Our Ref: BR/61/19/HH
Your Ref:

Town & Country Planning Act 1990 (as amended)
Town & country Planning (Development Management Procedure) (England) Order 2015
Application for Planning Permission for Works or Extension to a Dwelling

Development Ramp access to existing front door
Location 34 Ivydale Road Bognor Regis

PROPOSED SIDE ELEVATION 1:50

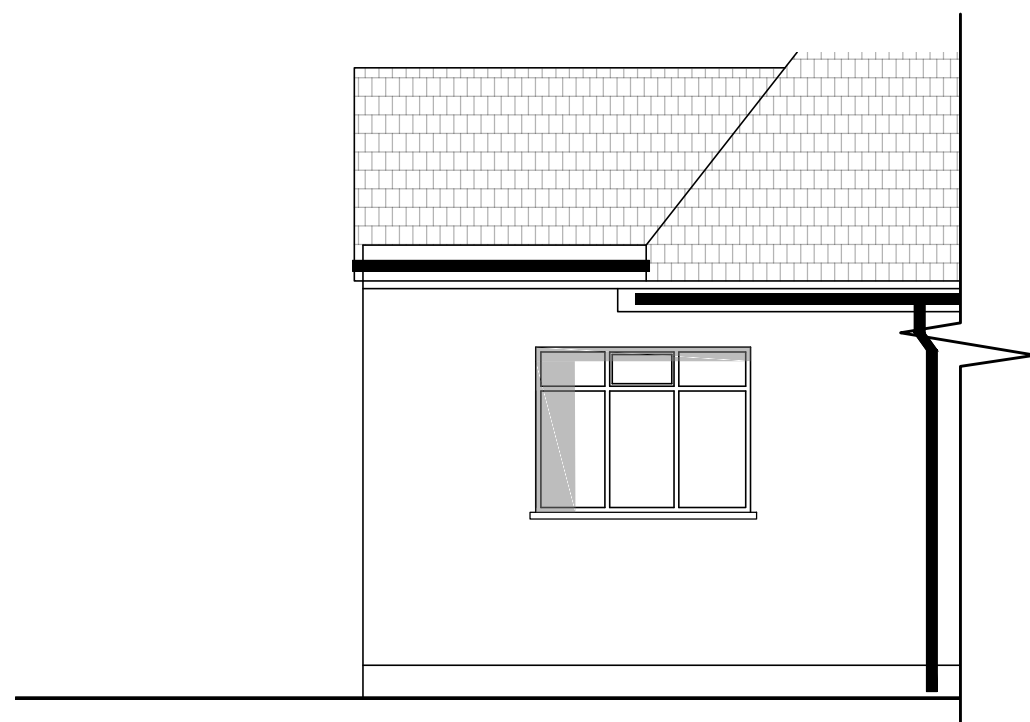
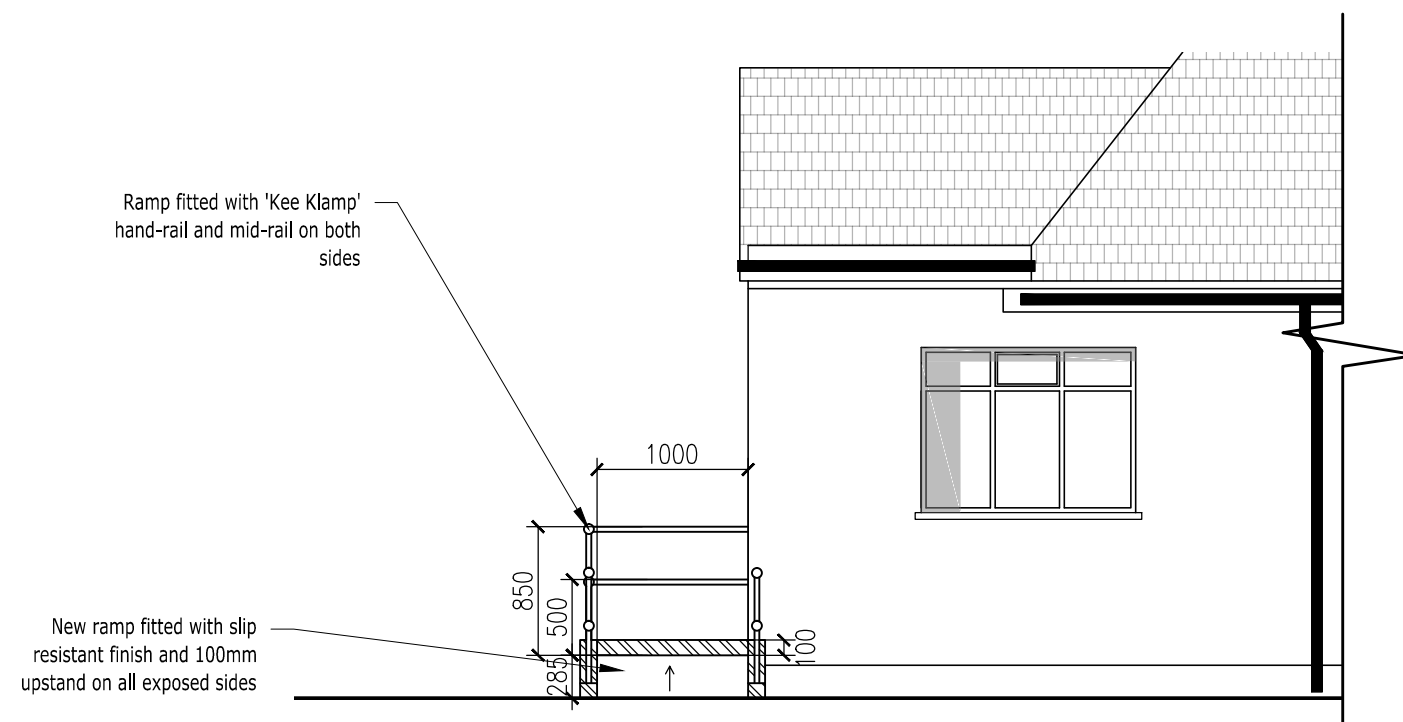
Side Elevations: Please provide the proposed side elevations for this application. Please submit these at a standard scale of 1:100 or 1:50.
